Engineers Comments Regarding Surface Water Drainage

Application Reference:	BE/146/25/DOC	Reviewer Reference:	ADC/EXT5/AF
Planning Officer:	Amber Willard	Date of Review:	23/04/2026
Site Name:	The Cottage Shripney Road Bognor Regis PO22 9PA		
Application Description:	Approval of details reserved by condition imposed under BE/176/21/PL relating to condition 26-surface water drainage.		
Assessment Number:	3

Comment 2: Flow control device evidence.

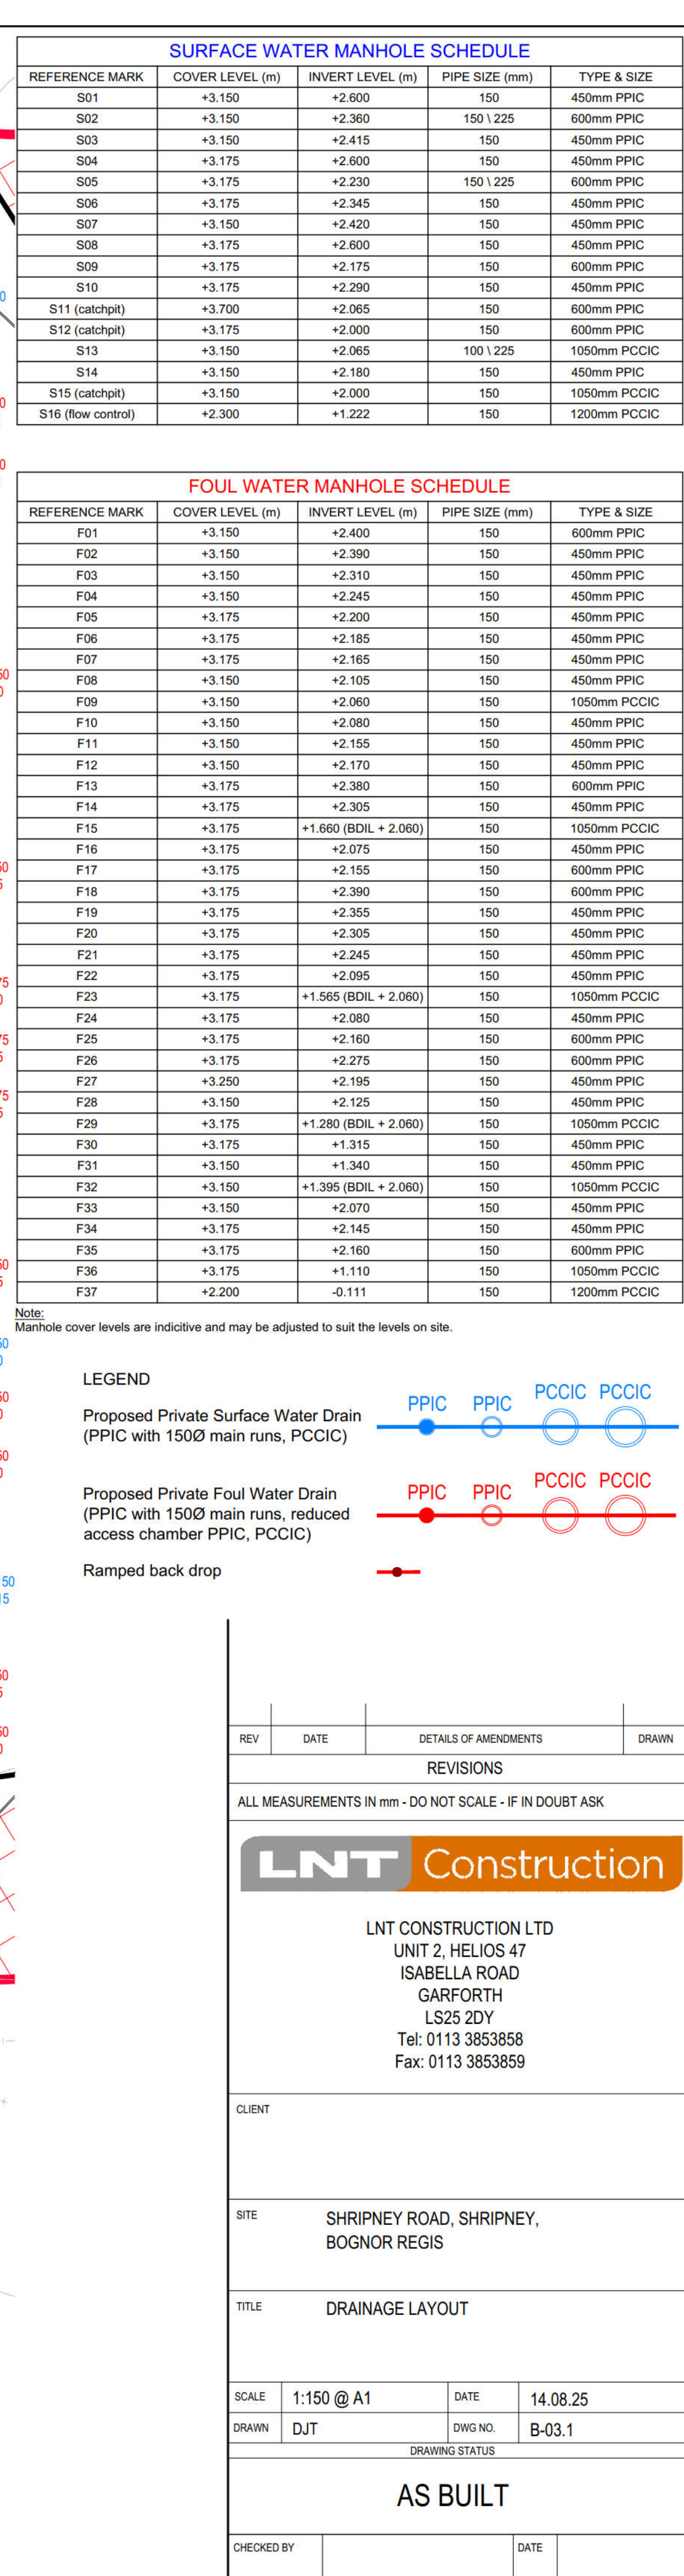
2.	The Flow control device should be evidenced to be installed in accordance with	Please see attached the as-built drainage survey which shows all of the schemes	In addition to the as built plan please provide evidence in the form of	Photographs: please see image attached.	Additional information acceptable, comment closed.

the approved plans including IL, type and product reference.	details and the fitment of the model/type and invert at the flow control manhole (S17). The drainage has been installed as per the spec, apart from some small alterations to the north with the inclusion of the land drain and resultant impact on some inverters in the area. The information on the as-builts shows the flow control unit, the specification as installed and the invert	photos and records particularly the flow control product including orifice size and depth to IL as the two main criteria controlling peak flow.	Orifice size: 75mm (attached technical specification previously submitted Ref. SHE-0075-2100-0550 2100_Design_Drawing) The document title shows the specific orifice size of that particular flow control device (added in bold for clarity). Depth to IL: Please see attached plan which shows the depth to IL (275mm), cut out image below for reference
